Merit Review of Environmental Assessment
Continuation of Bengalla Mine Project (SSD 4974 / EPBC 2012/6378)

Attachment A – Detailed Comments on Environment Impact Statement, September 2013

Document Title: **Bengalla Continuation of Mining Project** Environmental Impact Statement (In particular, *Main Report*; Appendix J *Surface Water Impact Assessment*; Appendix K *Groundwater Impact Assessment*; Appendix O *Ecological Impact Assessment*; Appendix X *Dry Creek Interim Management System and Conceptual Re-instatement Study*), September 2013.

Proposed action: Continuation of Bengalla Mine (EPBC 2012/6378) – Expansion

Figure 10.1 Conceptual proposed re-established Dry Creek alignment

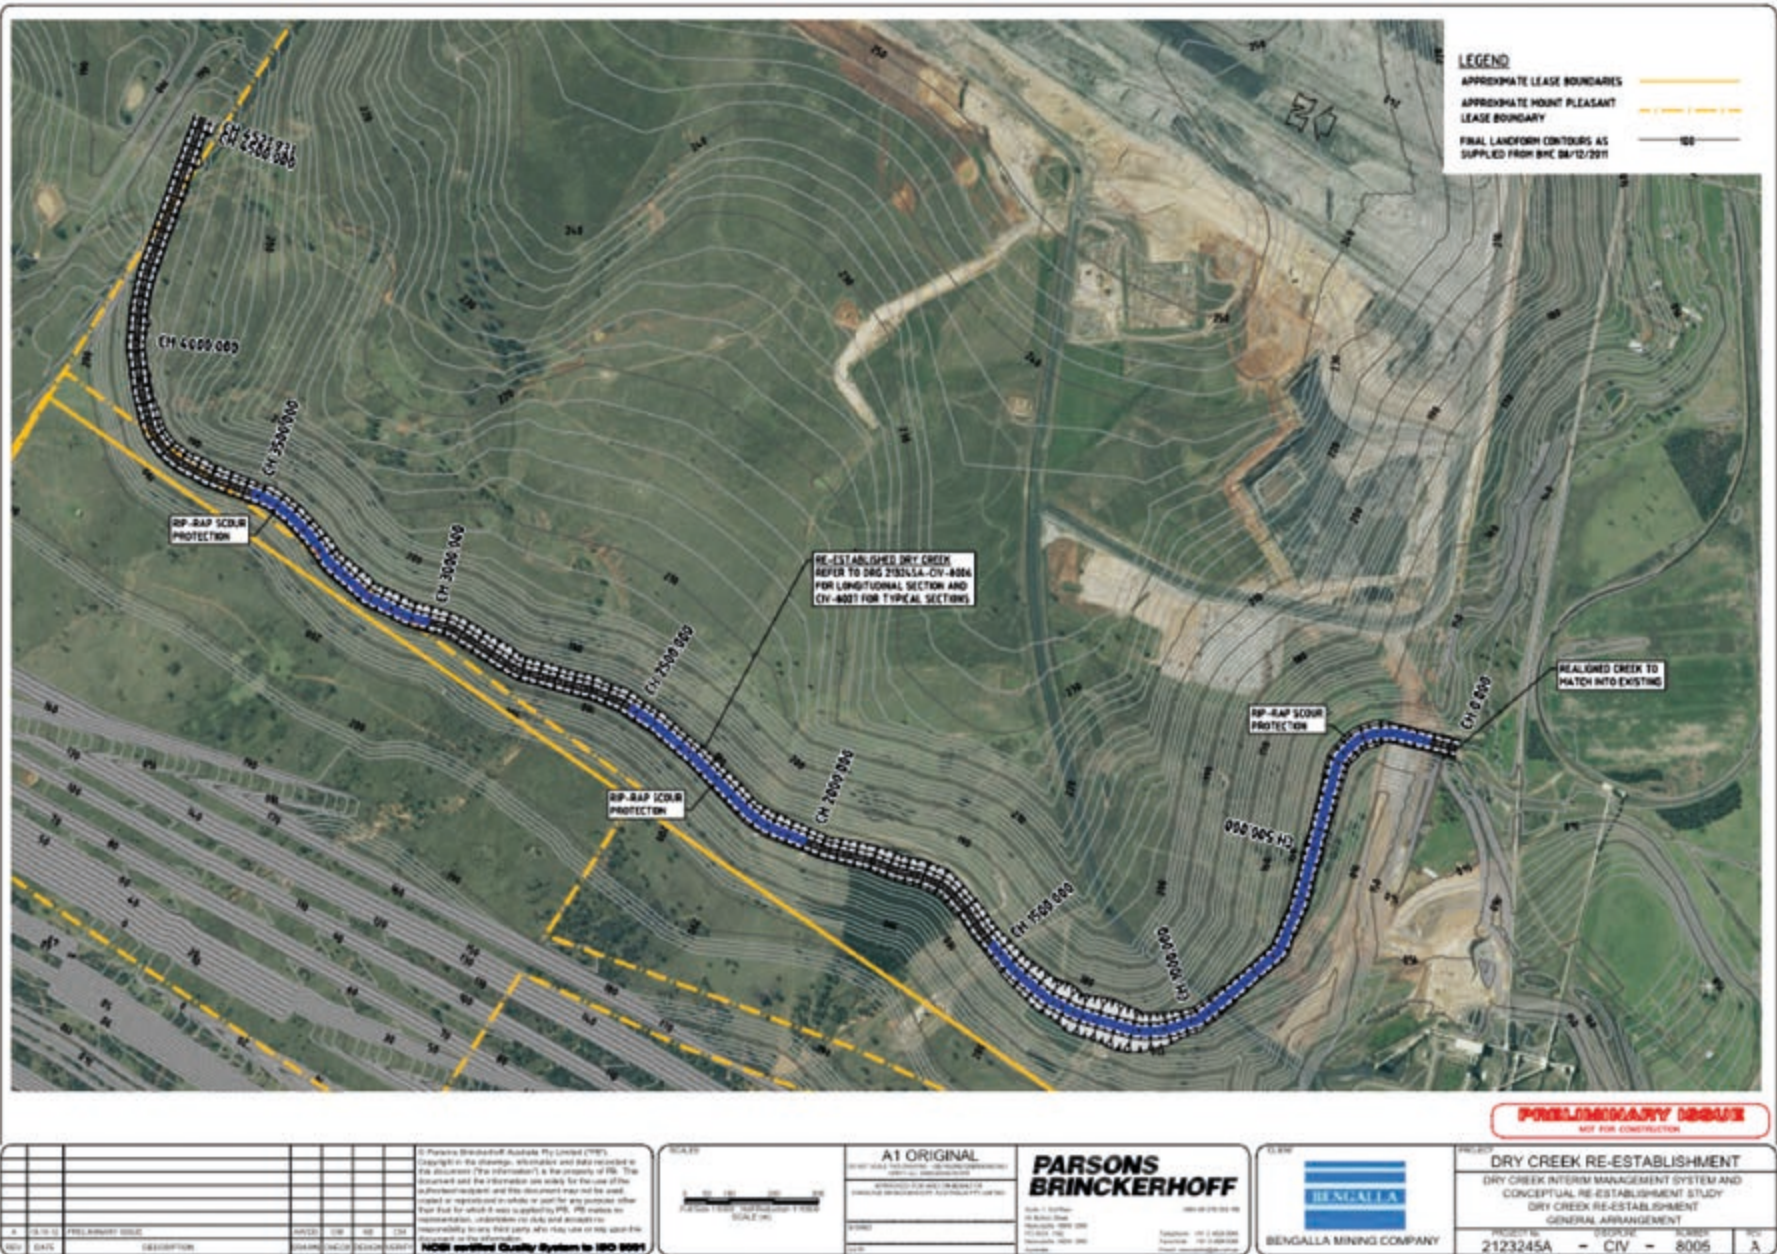
- ii. leachate seepage paths and containment mechanisms, and
 - iii. the proximity of the reinstated Dry Creek to potentially acid forming and sodic materials;

Figure 10.2 Conceptual proposed cross section for Dry Creek

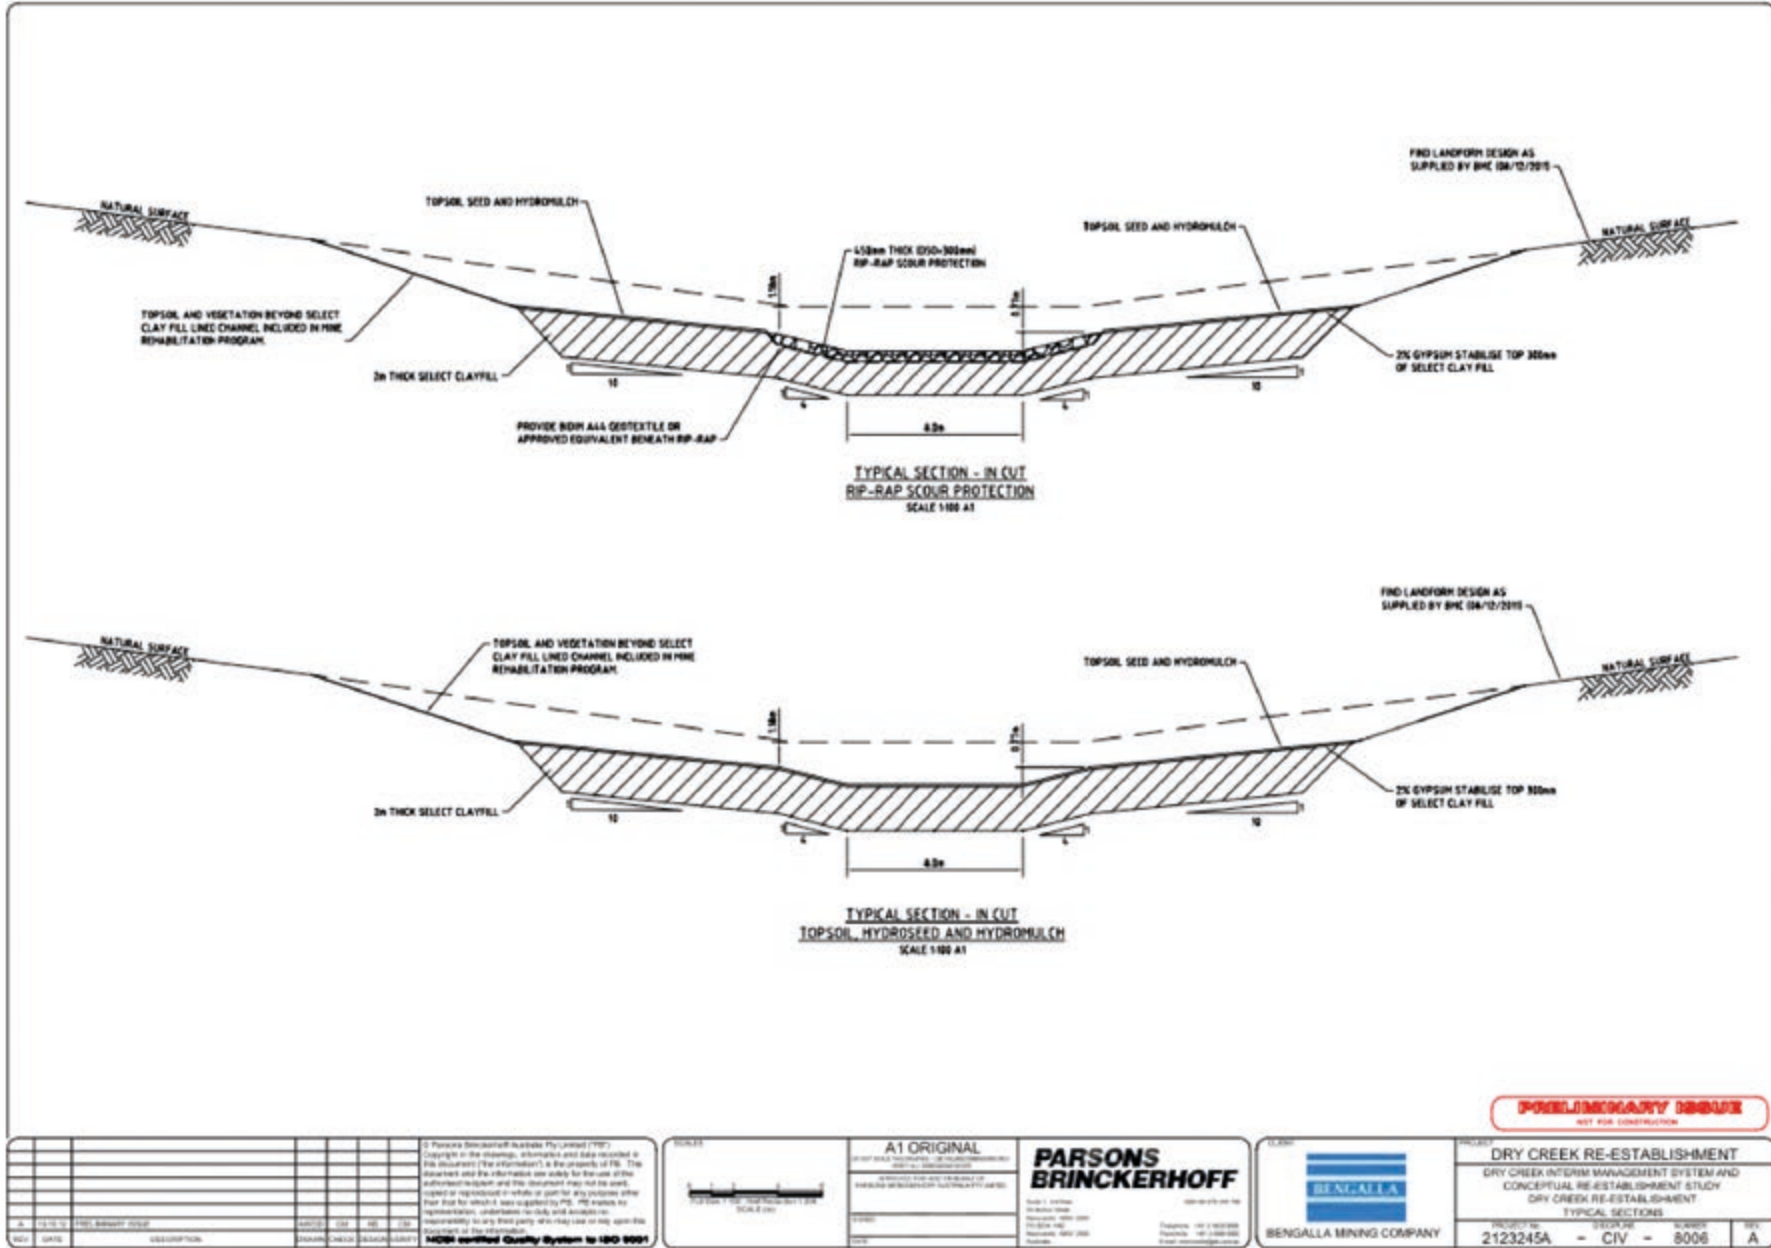
It is unclear whether the design of the reinstated Dry Creek incorporates proposed discharges from the adjacent Mount Pleasant operation.

12. It is unclear whether the design for the reinstatement of Dry Creek has provided for discharges from the Mount Pleasant Mine. Clarification of this issue should be sought, and if necessary, the design should be amended to incorporate the maximum anticipated discharge volumes from the Mount Pleasant Mine.
